Charlotte Department of Transportation

Memorandum

Date: March 4, 2008

Subject: Rezoning Petition 08-056: Located on the southwest corner of Nations Ford Road and West Tyvola Road

**TYVOLA APARTMENTS**  
**REZONING PETITION NUMBER 2008-056**  
 HATHAWAY DEVELOPMENT  
 TECHNICAL SITE PLAN

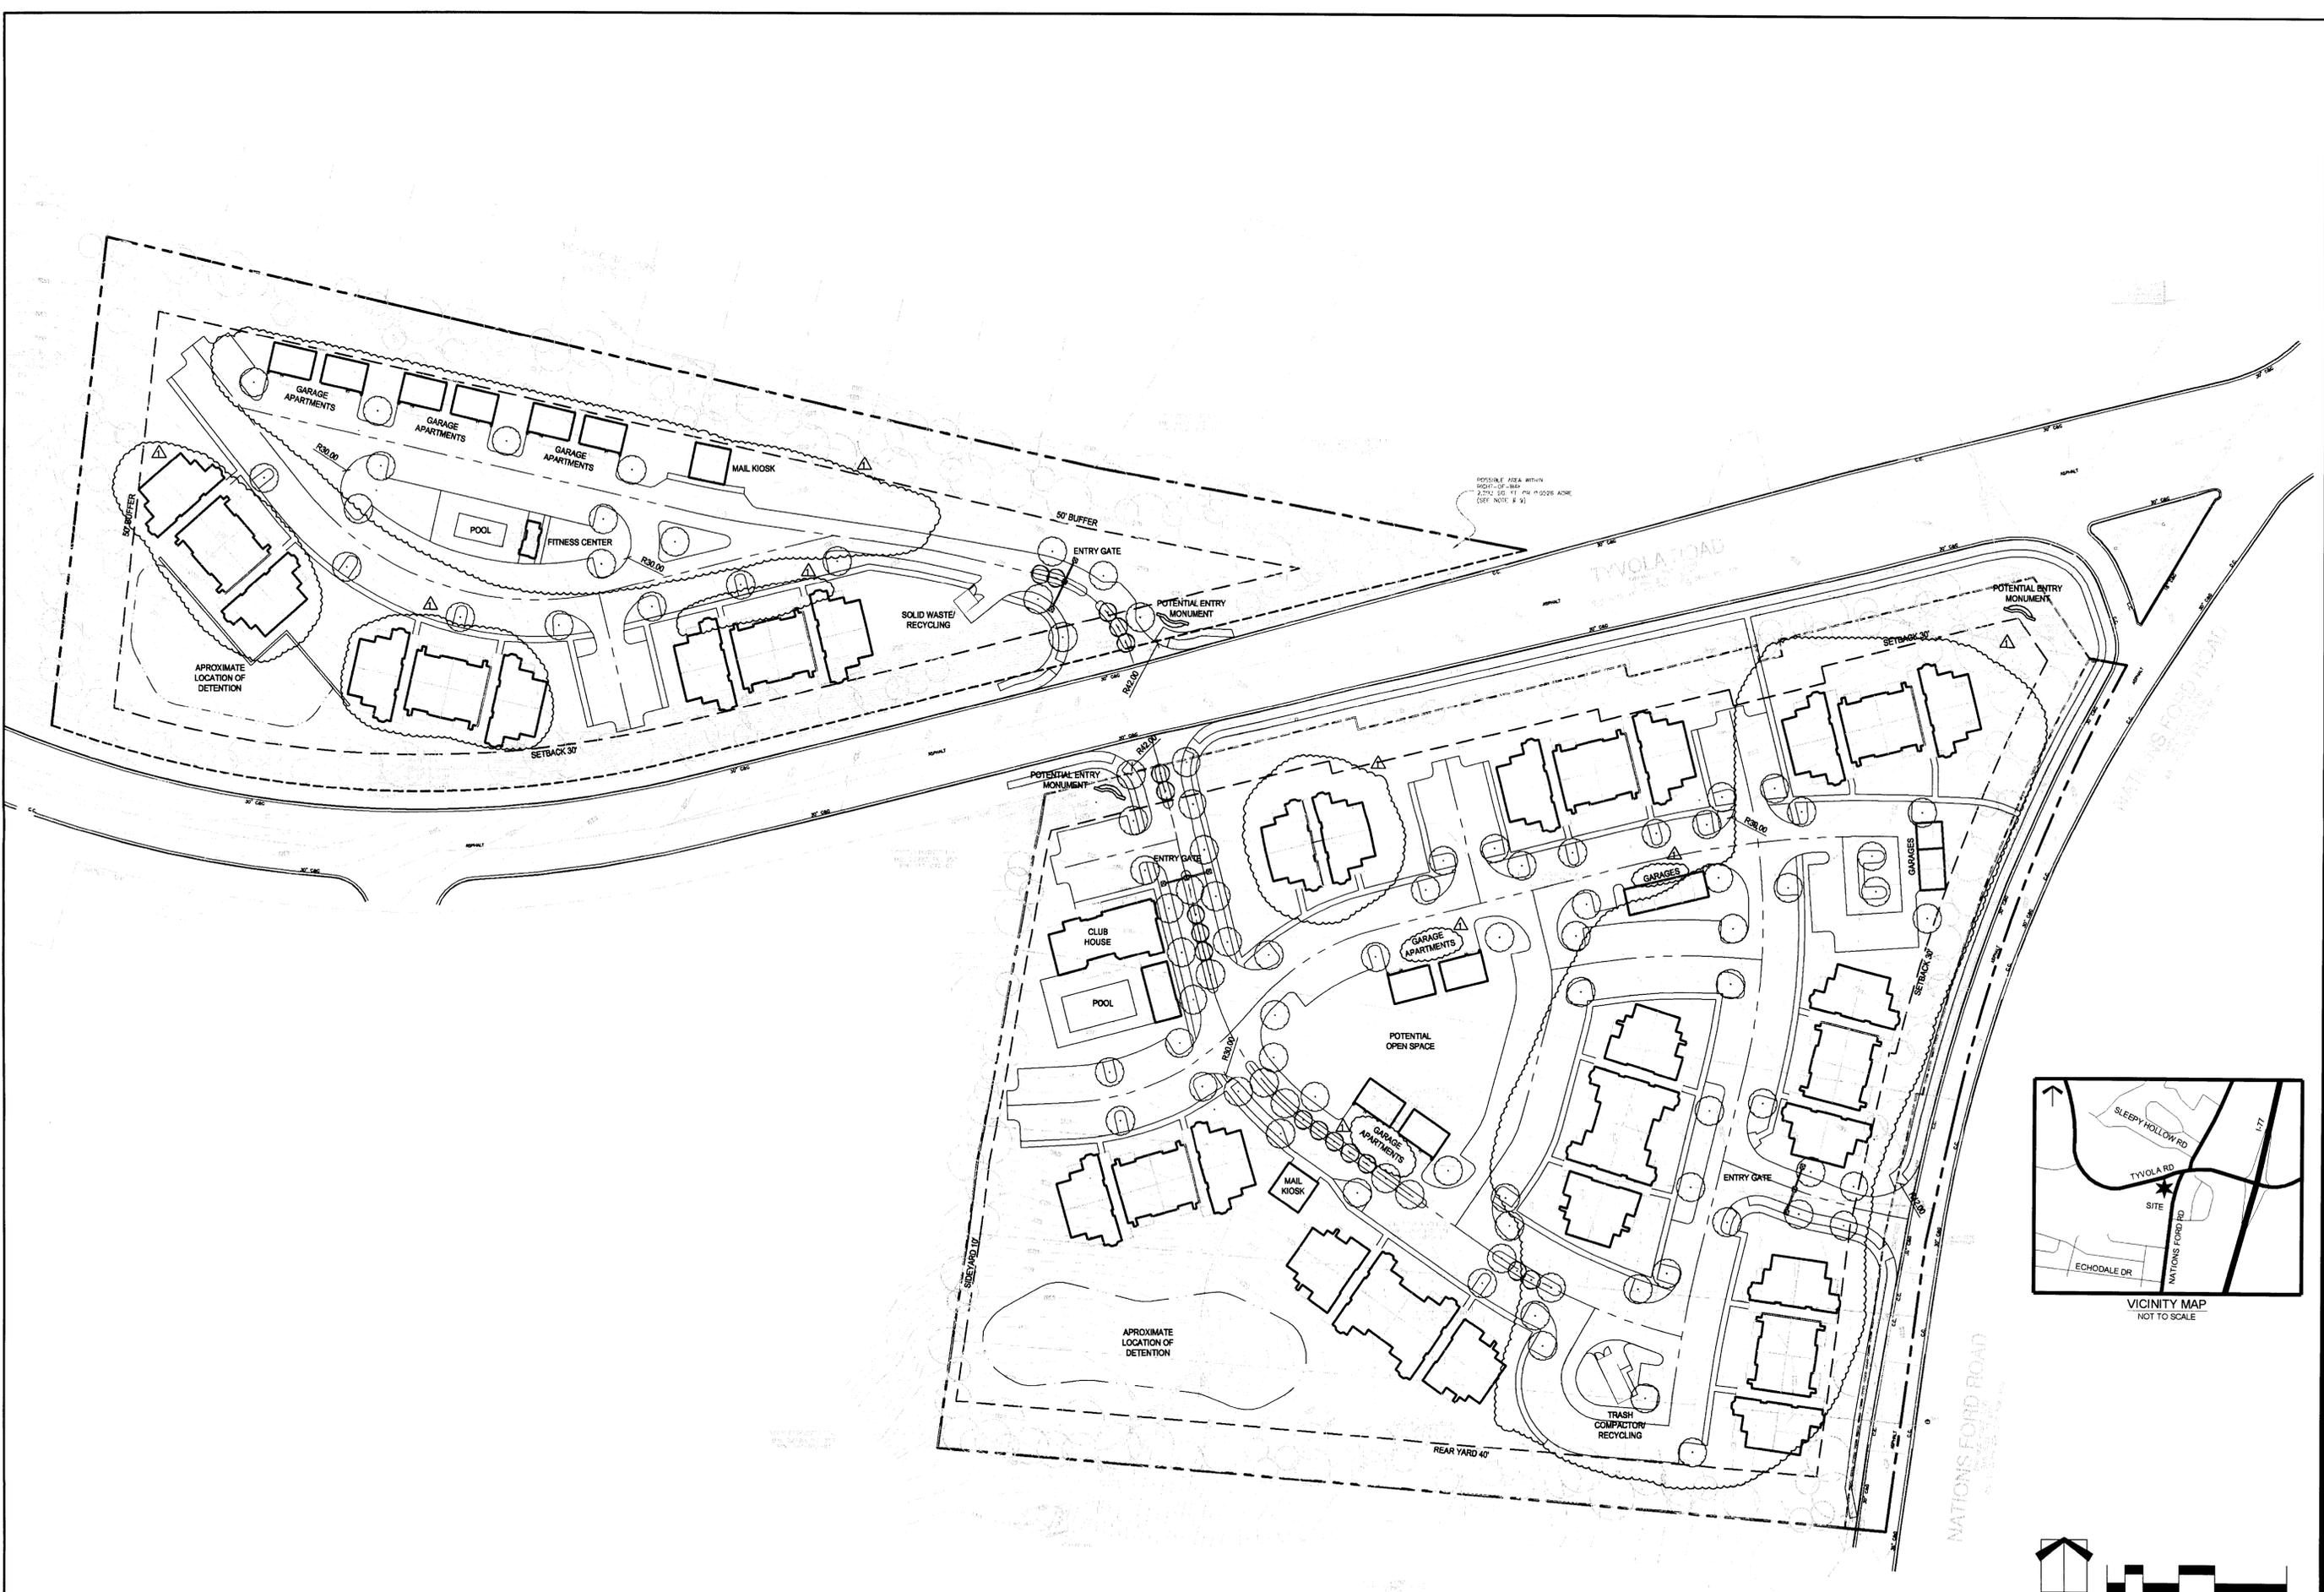
1. Left-turns into the proposed driveway cannot be made safely due to the left-turn offset/conflicts. For this reason, CDOT has determined that left-turn lanes on West Tyvola Road and Nations Ford Road are necessary to serve the traffic using the proposed private

driveway connections for this site. On West Tyvola Road the left-turn lane can be provided by relocating the driveway to the west and restriping the existing painted out median area. The engineering design and construction of the left-turn lane is the responsibility of the owner and shall be performed by a professional engineer registered in the State of North Carolina who has roadway design experience. The design of left-turn lanes need to comply with NCDOT design guidelines with a minimum of 150 feet of storage and will be reviewed during subsequent permitting processes.

2. The site plan needs to show 6-foot sidewalks and 8-foot planting strips along both West Tyvola and Nations Ford Roads, as measured from any future curb line. CDOT will determine the location of any proposed curblines during the building/driveway permit process.
3. Parcel A needs to have an additional internal street connection to the adjacent multifamily Parcel B. Although a stub connection is shown to the south, one is also needed to the west to provide better inter-connectivity. The site plan needs to be revised accordingly.
4. Additional comments and any required transportation improvements will follow our review of the TIS.

1. This site plan does not adequately integrate transportation and land use. As currently proposed, the development is too auto-oriented with buildings oriented away from any street and a layout discouraging walking, cycling and transit.
2. An internal system of 5' sidewalks connecting the buildings/uses both within the site and from the building entrances to sidewalks along West Tyvola Road and Nations Ford Road is needed.

Adequate sight triangles must be reserved at the existing/proposed street entrance(s). Two 35' x 35' and two 10' x 70' sight triangles are required for the entrance(s) to meet requirements. All proposed trees, berms, walls, fences, and/or identification signs must not interfere with sight distance at the entrance(s). Such items should be identified on the site plan.

- Dimension width of the existing and proposed driveways.
- New/reconstructed driveways must be drop curb ramp Type II-Modified driveways.
- Indicate the locations and widths of all adjacent and opposing driveways.
- Indicate typical parking module dimensions.
- Directional wheelchair ramps (two per corner) should be provided at all intersections of public and private streets.
